27 March 2023

Our Ref: 2023/130275
File No: R/2023/8

Harbourside Shopping Centre Redevelopment – Advice on SSD 49295711 – Podium and Tower

Figure 26 'Kit of parts' facade options and resultant facade articulation - Waterfront Promenade
Source: Snøhetta and Hassell

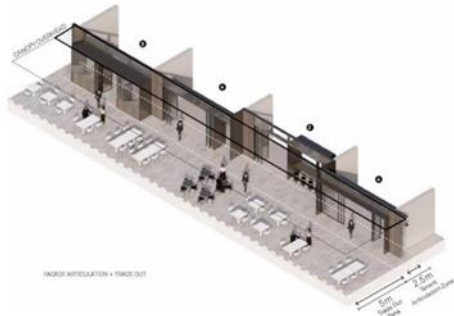
There is no objection to the 'kit of part' façade options approach for the ground level retail. There are four arrangements documented with varying degrees of solidity.

However, the City recognizes the risk that Type 4 may be the only shopfront desired by the retailers, which will detract from the carved sculptural idea for the podium that was key to the scheme prevailing at the design competition. The de-materialisation of the ground level is further exacerbated by the southern retail precinct, where the shopfronts are predominantly glass and appears to have light weight metal elements.

If each shopfront type had a minimum proportion of solid elements, then this could contribute to the overall solidity of the podium. This risk should be managed through an appropriate condition or redesign.

1 GA - North Elevation
1 : 500

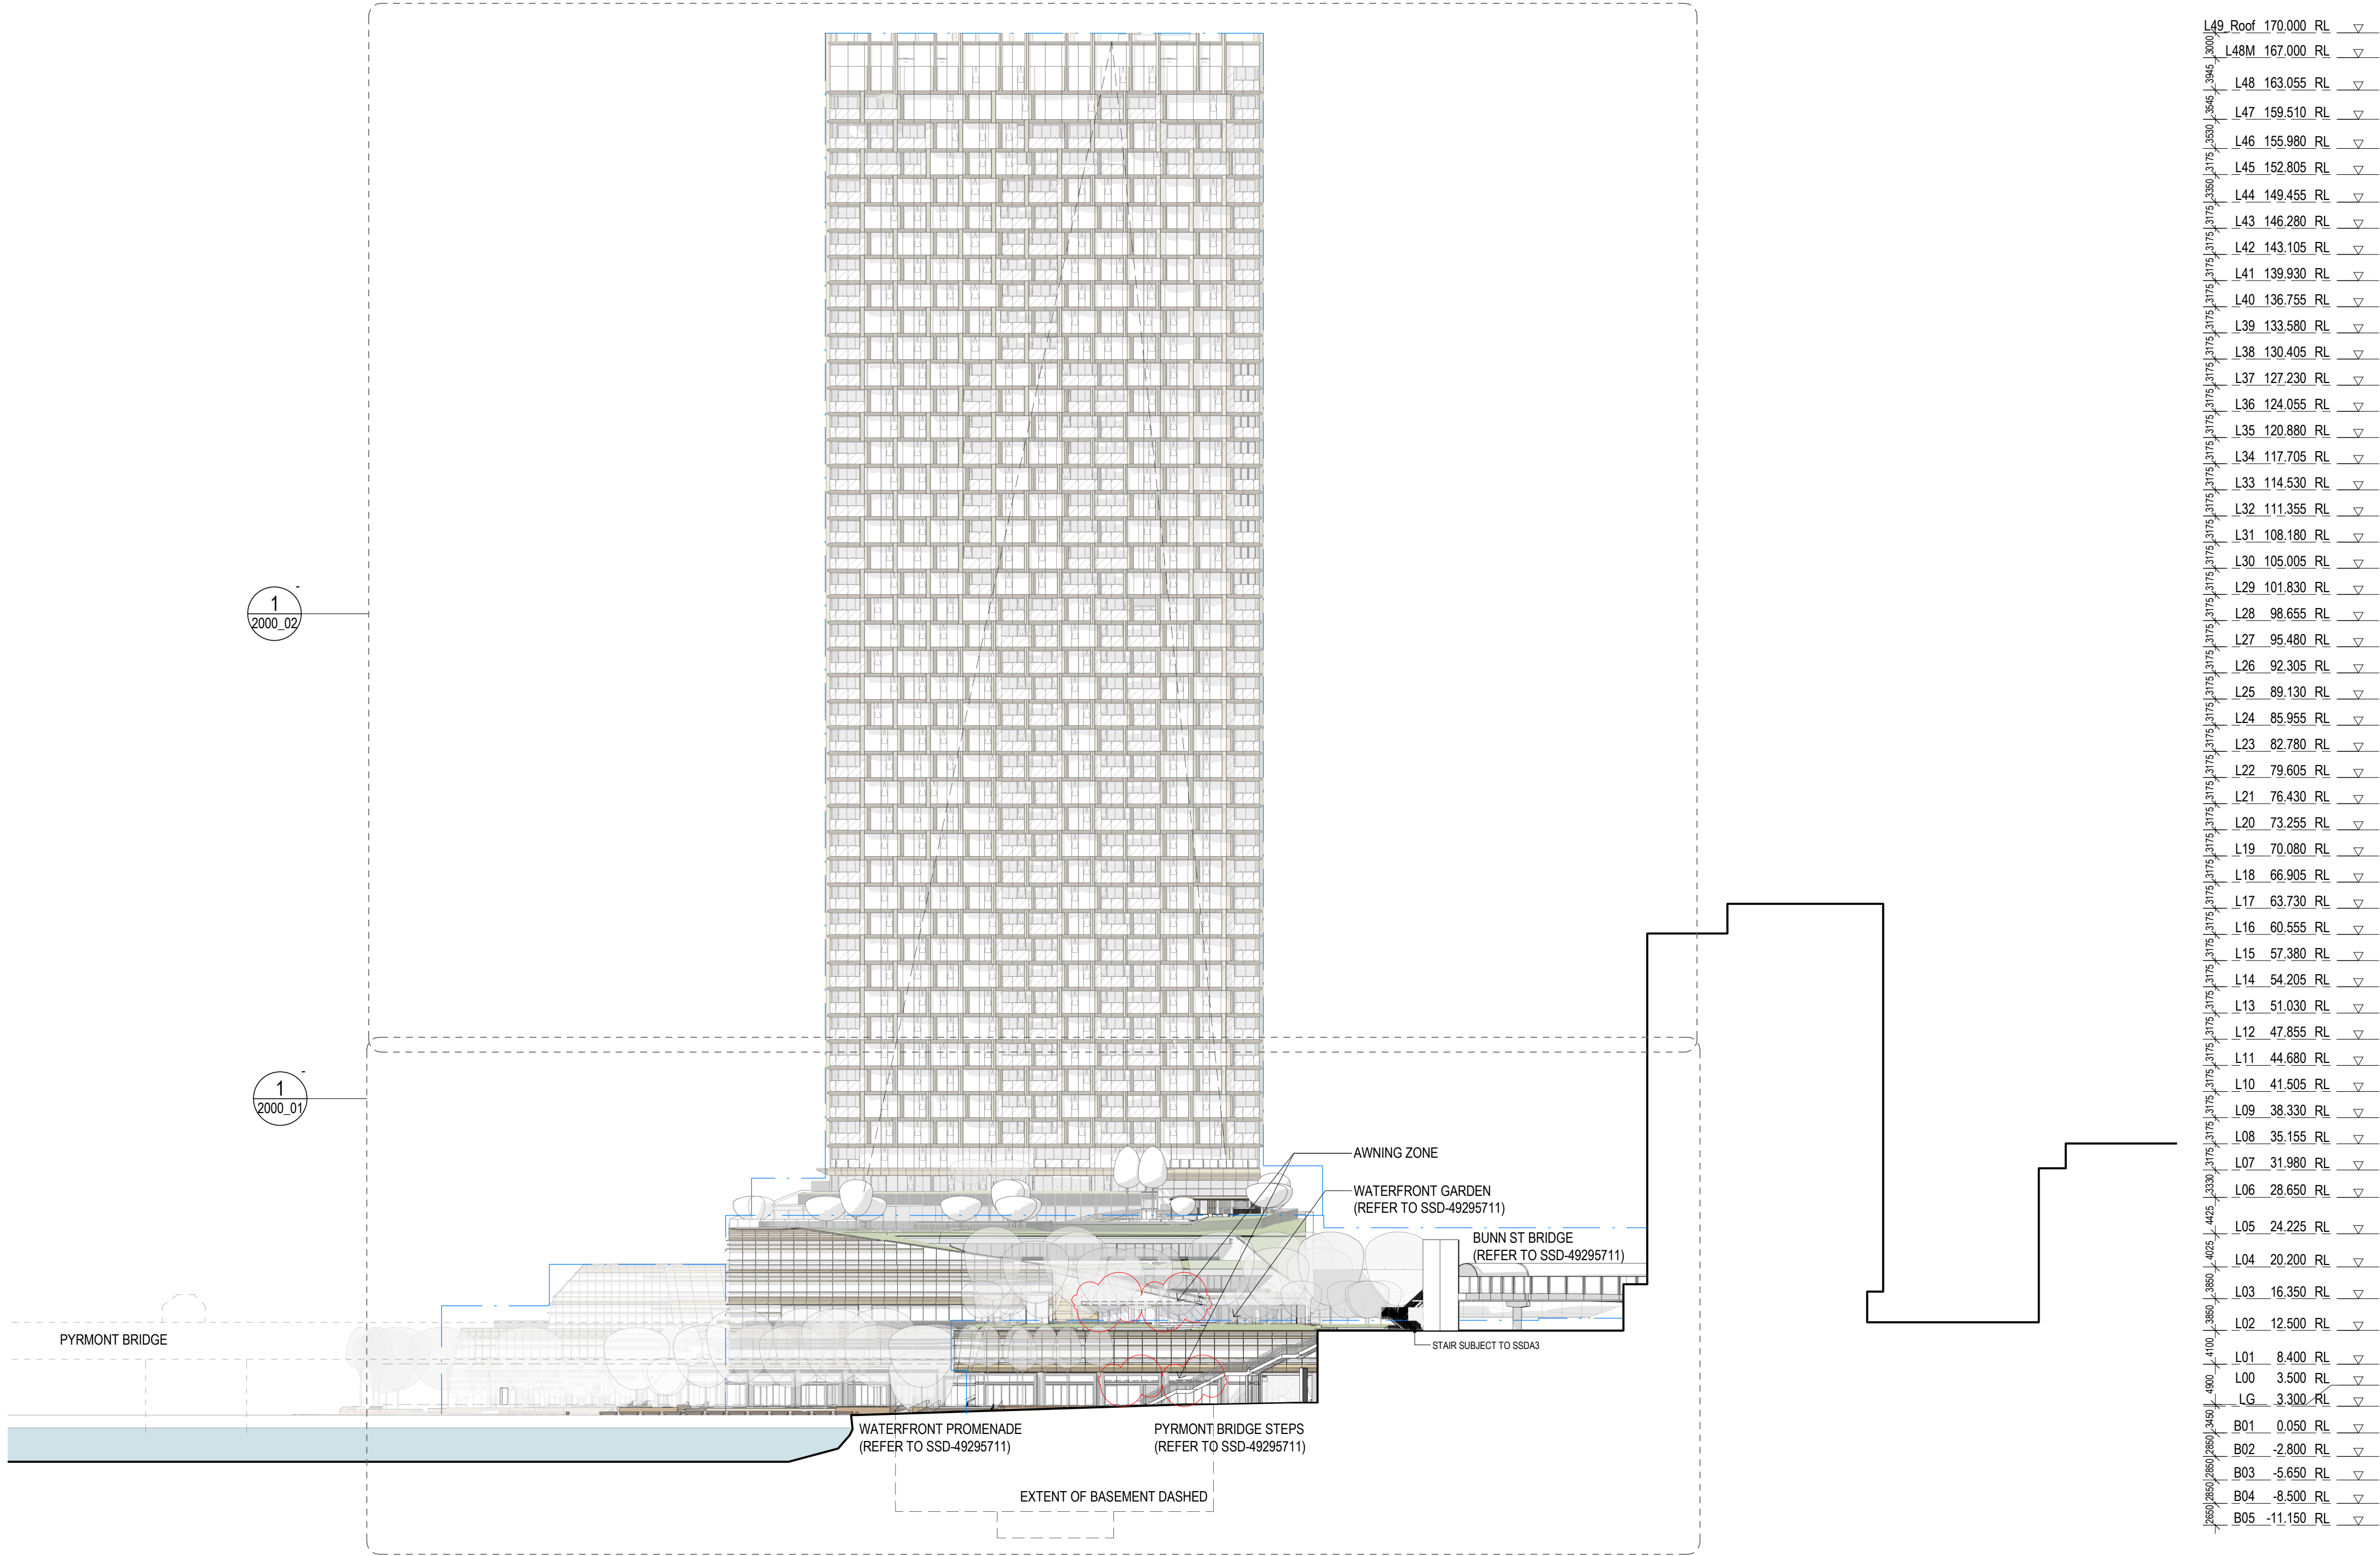
The façade types, materials and finishes require coordination and consistency between the design report and the architectural package. The elevations only identify two façade types; the podium and the tower, despite the four façade types that comprise the podium. If relying on the architectural package alone, it would be fair to think that a singular expression (FA-01) was being proposed for all elevations.

The sections in the architectural plans do not clearly make allowance for soil depth for the proposed landscaping and “folded landscape”. East and north elevations and section H indicates folded landscape on inaccessible and steep slopes at approximately 45 degrees.
